WEST SUSSEX COUNTY COUNCIL CONSULTATION

TO:	Arun District Council FAO: Michael Eastham
FROM:	Stephen Gee WSCC - Highways Authority
DATE:	29 April 2021
LOCATION:	Tye Lane Walburton BN18 0LU
SUBJECT:	WA/93/20/PL Alternative access & emergency access along with minor highway works following WA/95/18/RES. This site is in CIL Zone 2 (Zero Rated) as other development.
DATE OF SITE VISIT:	n/a
RECOMMENDATION:	More Information
<u>S106</u> CONTRIBUTION TOTAL:	TBC

Drawing Title:
**PROPOSED ACCESS IMPROVEMENTS
- TYE LANE/AVISFORD PARK ROAD**

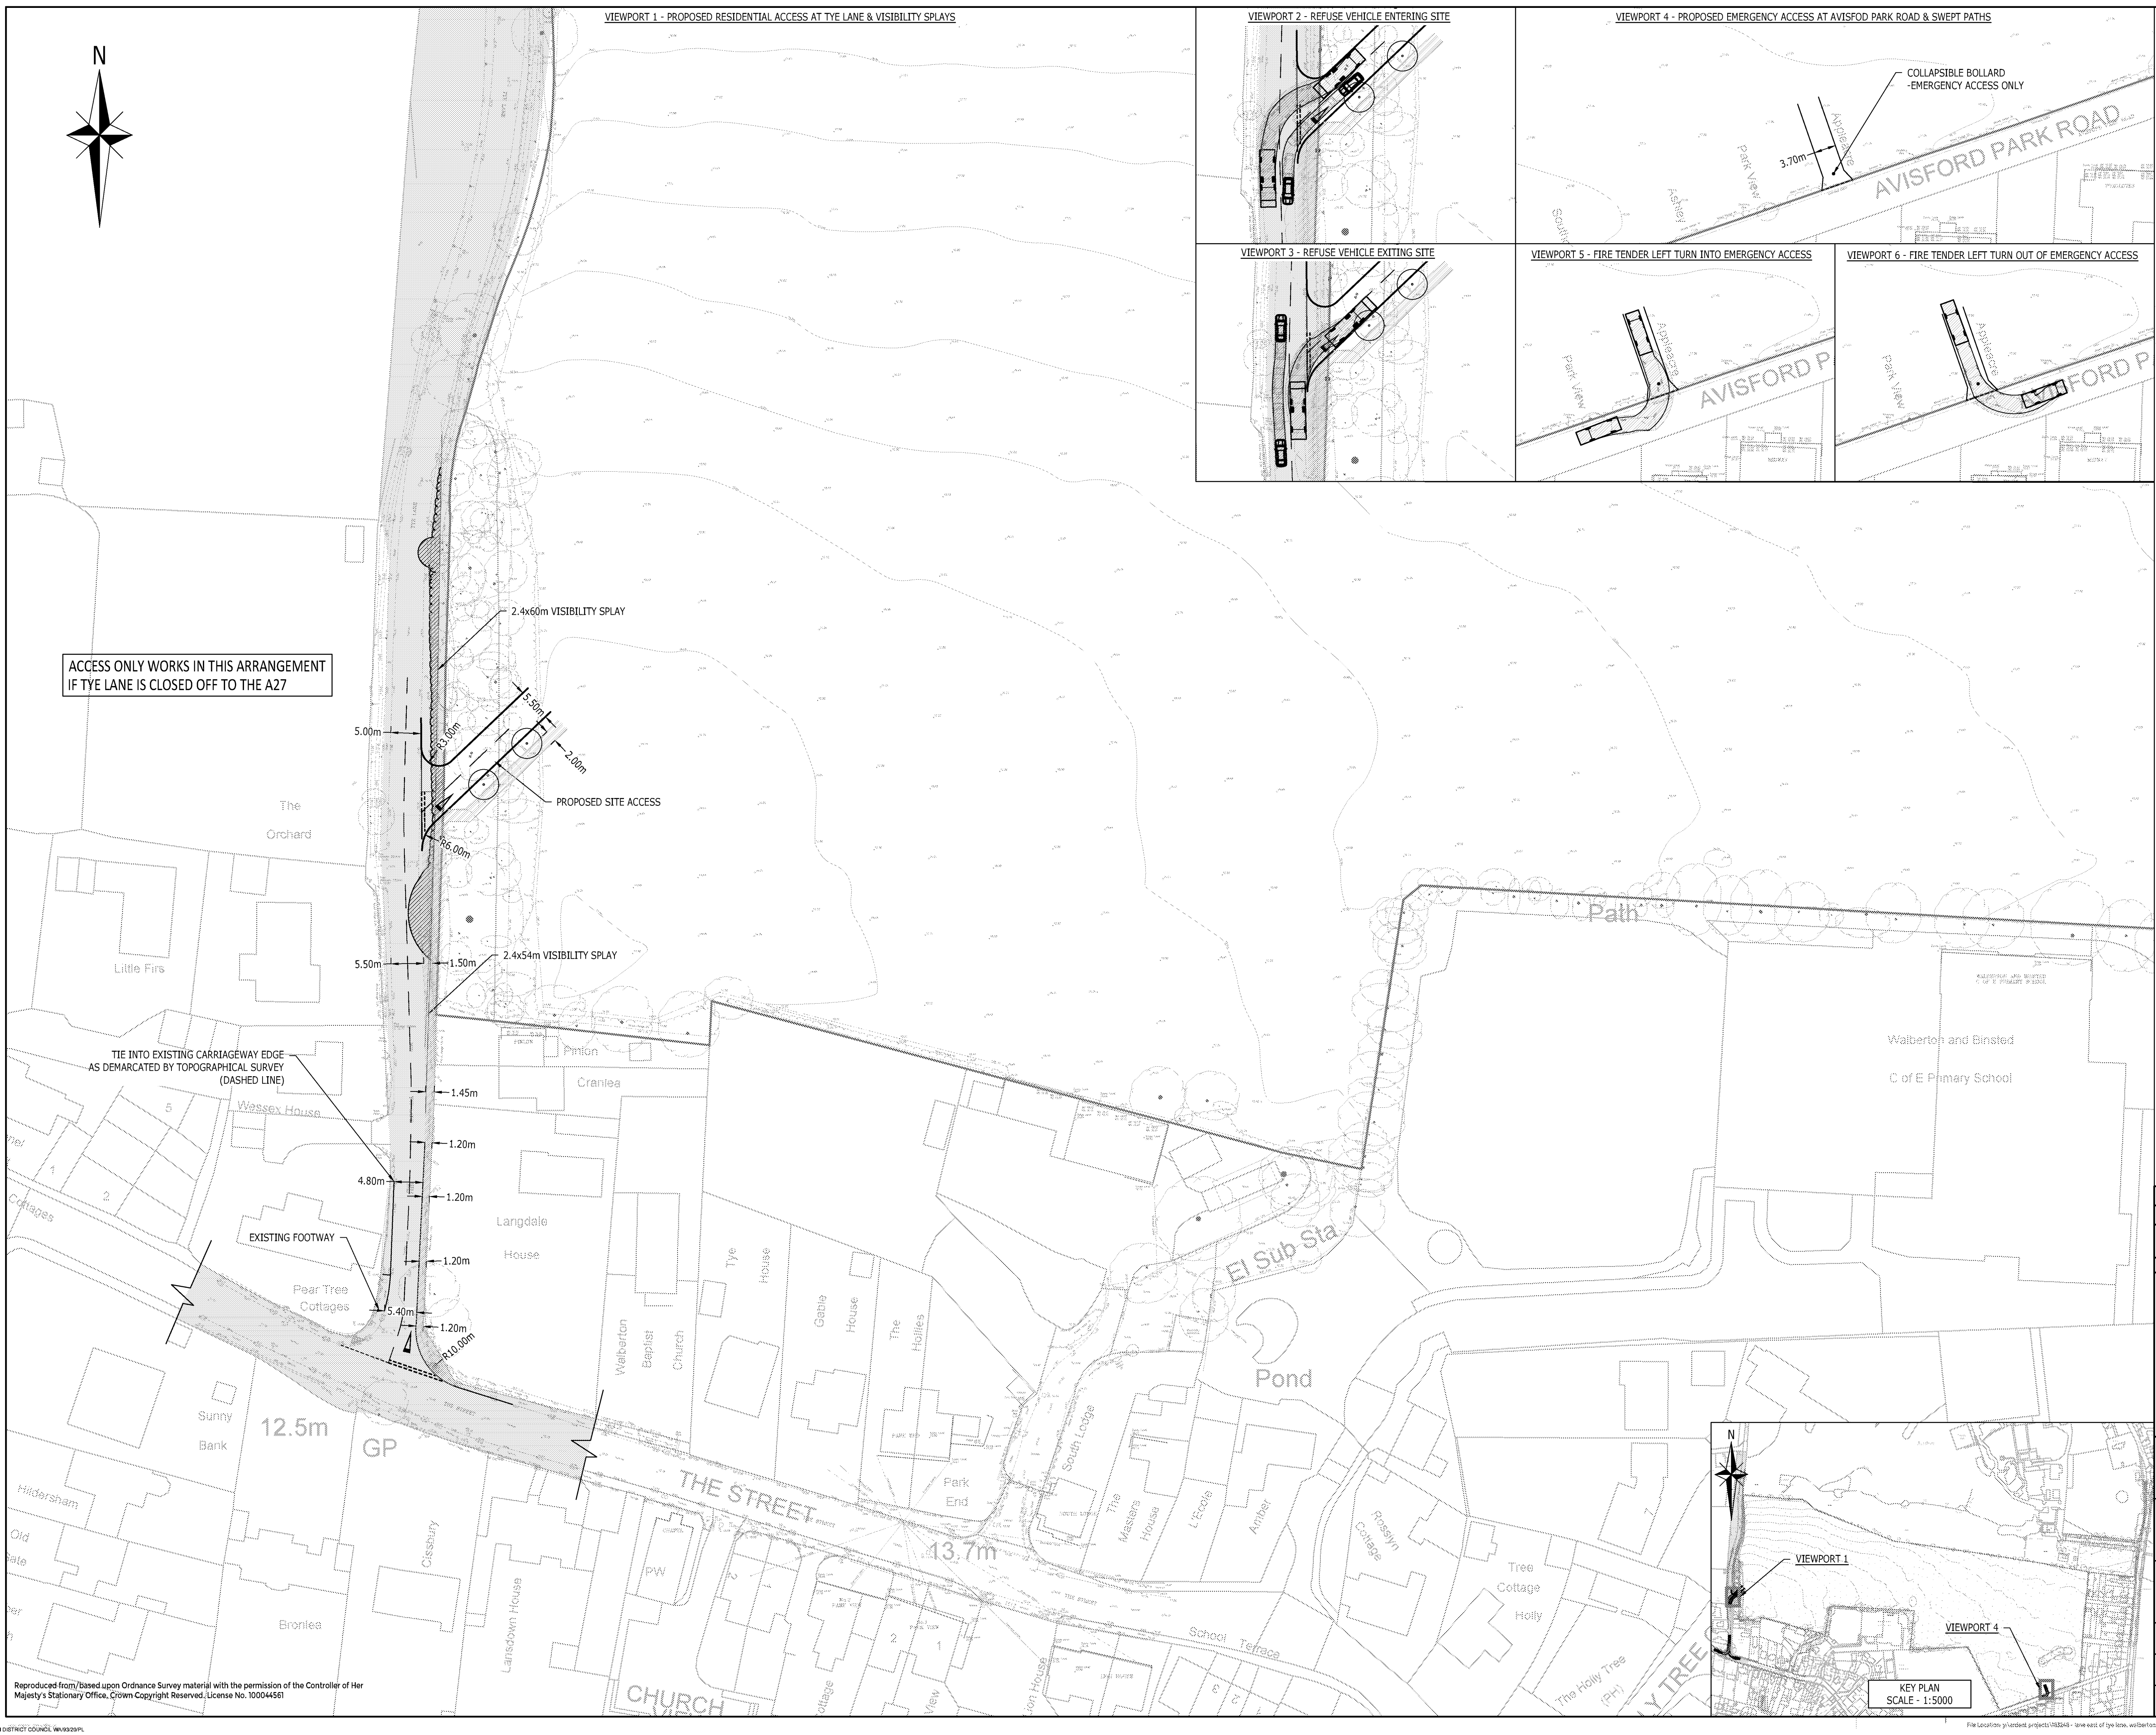
The minimum footway width along Tye Lane has been increased to a minimum of 1.2m for approximately 25m by reducing the running carriageway to a minimum of 4.8m; given alternative pedestrian access is available and the planning permission would only be implemented should the preferred route announcement be confirmed and implemented and as such Tye Lane would be closed to the North then no concern is raised.

Vehicle tracking has been provided for the emergency access which shows a Fire Tender can utilise the access and internal link within the development.

A1 Scale	Date	Designed by
1:500	23.02.21	DV
Drawn by	Checked by	Approved by
DV	DH	KM
Drawing Number	183248-004	Rev A

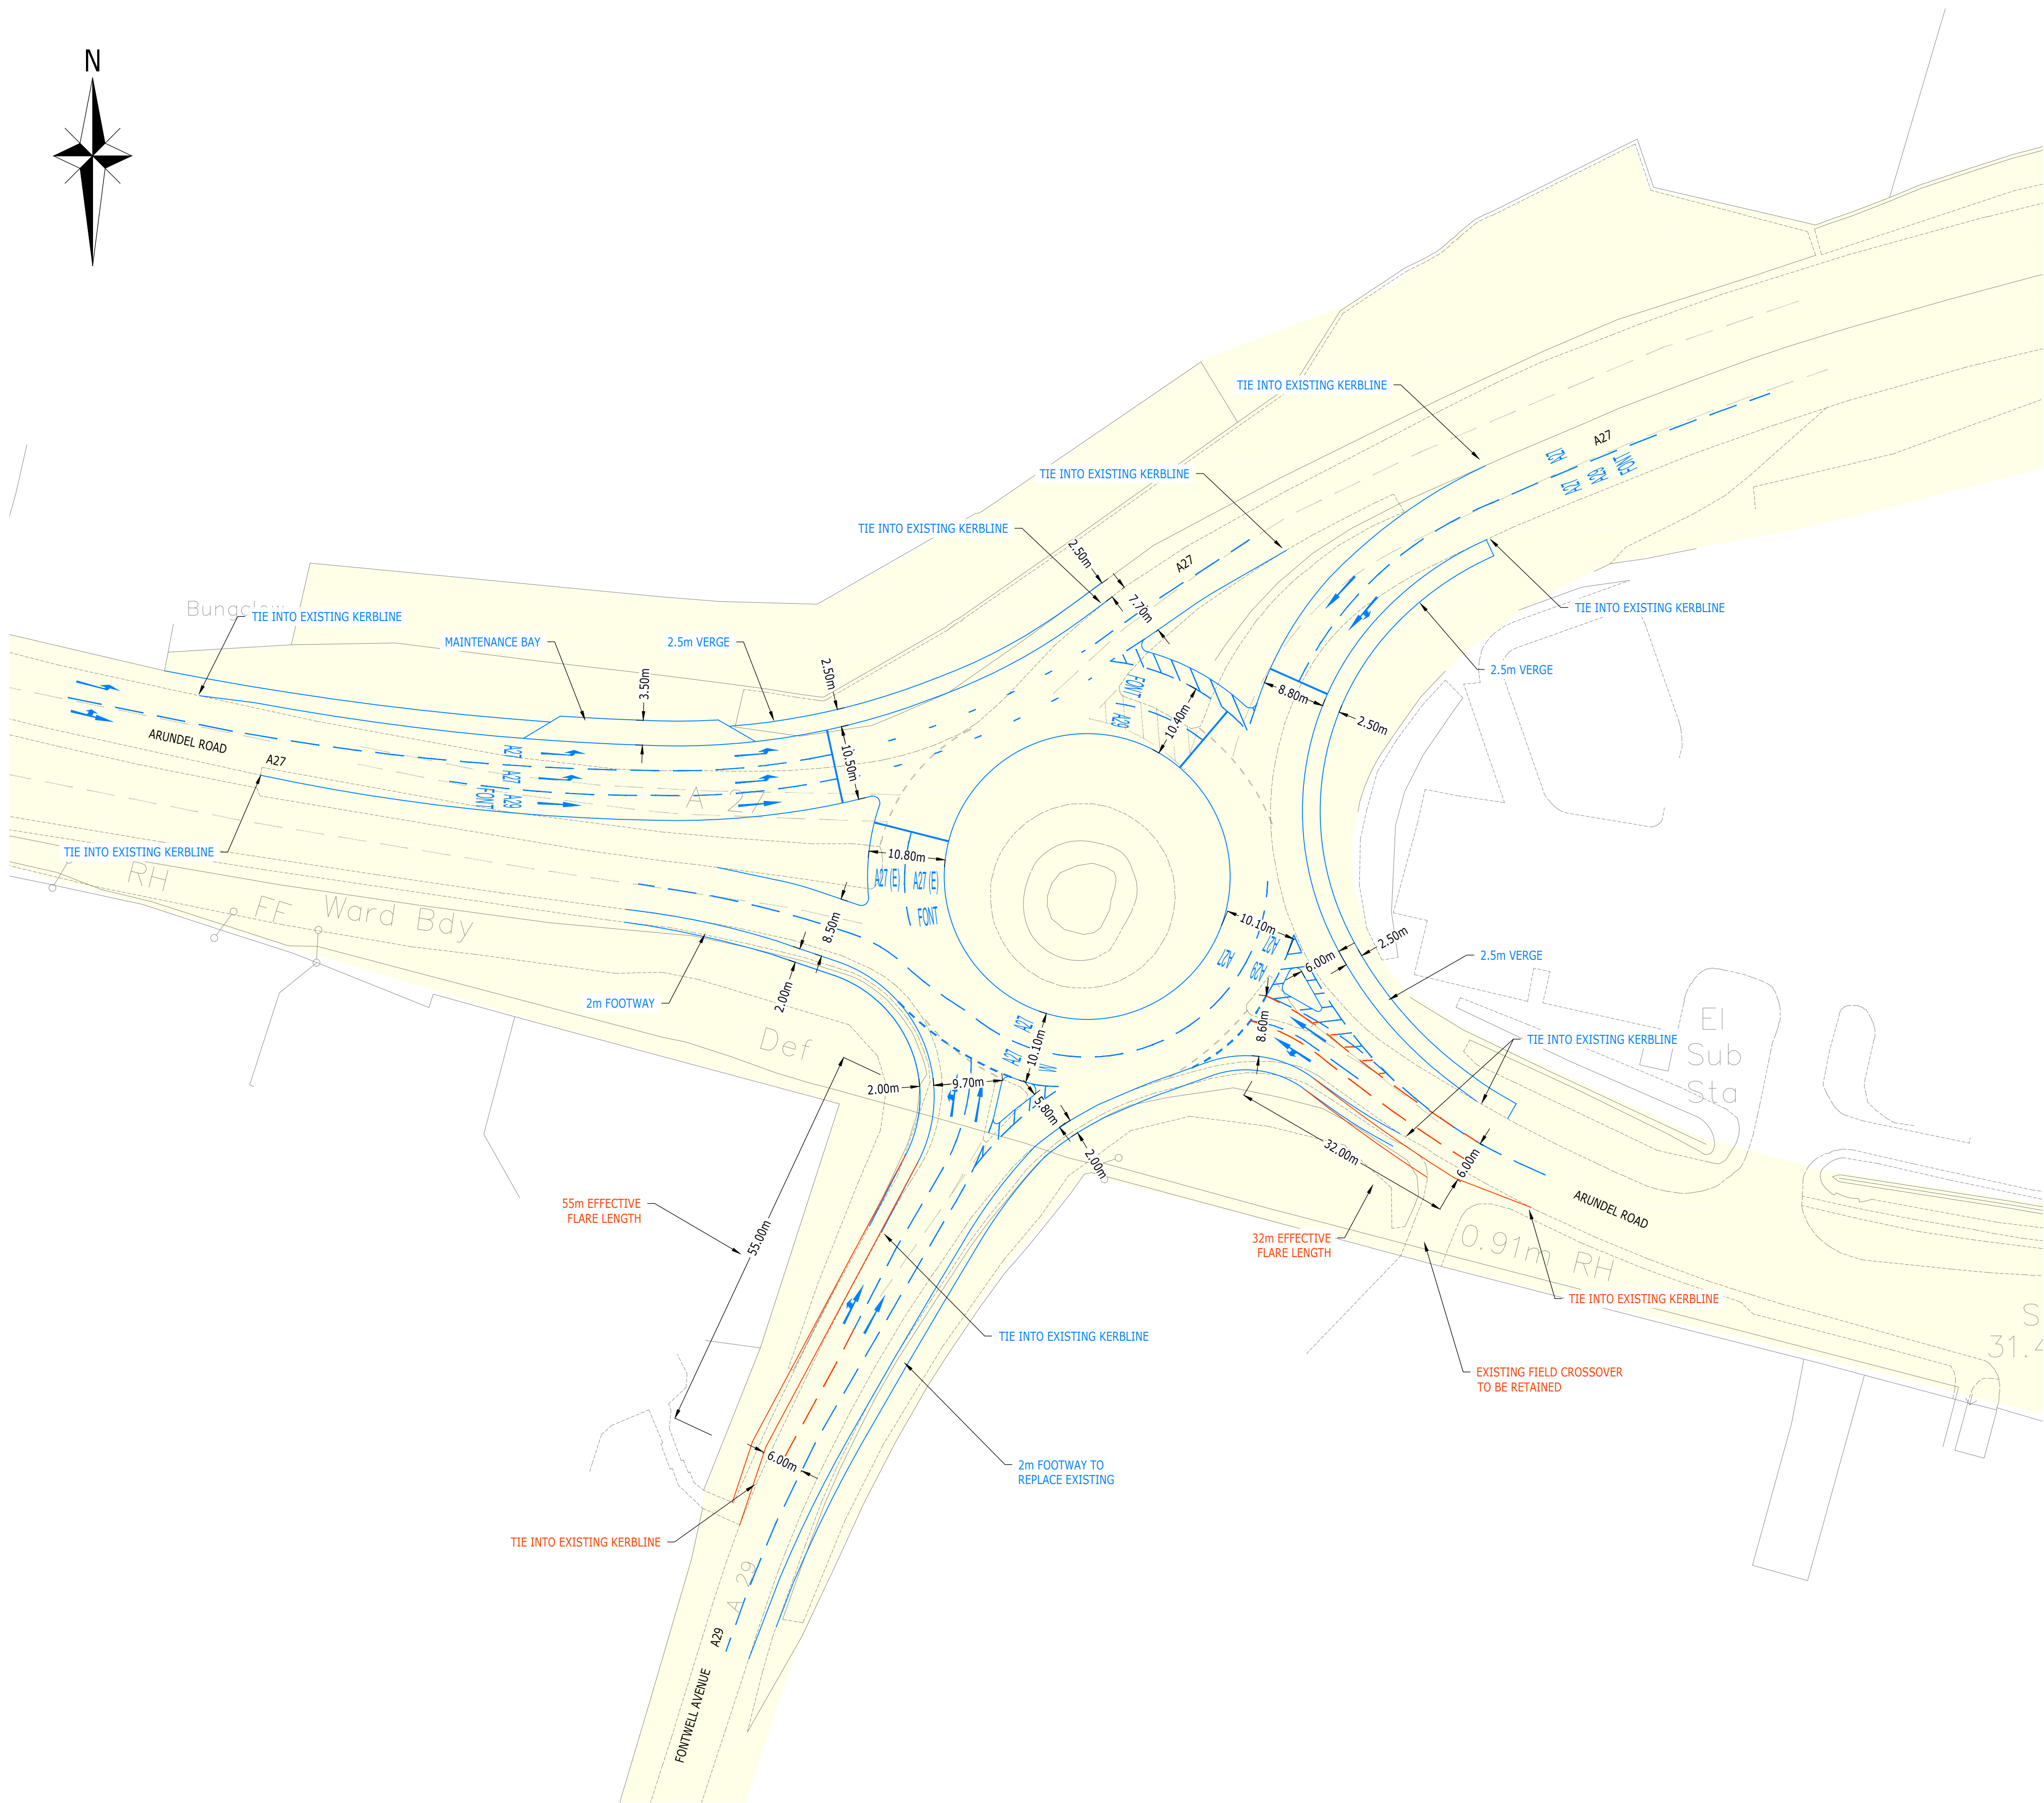
A mitigation scheme of widening the effective flares of the Arundel Road and A29 approach has been proposed and modelling provided to assess its impact.

WSCC raise concerns that the baseline data utilised does not accurately reflect the current Arundel Bypass Preferred Route Announcement scheme as the flows utilised in the modelling come from the Arun Local Plan Arundel Bypass model run which does not include the closure of Tye Lane and Yapton Lane therefore the wider rerouting (especially on Arundel Road) would not be included.

As the planning application would only be implemented should the Arundel Bypass be approved then this should form the baseline assessment which it currently does not.

Further Information is requested to determine the developments impact on the A27/A29 Fontwell West junction with the Arundel Bypass Flows that accurately reflect the Preferred Route Announcement scheme.
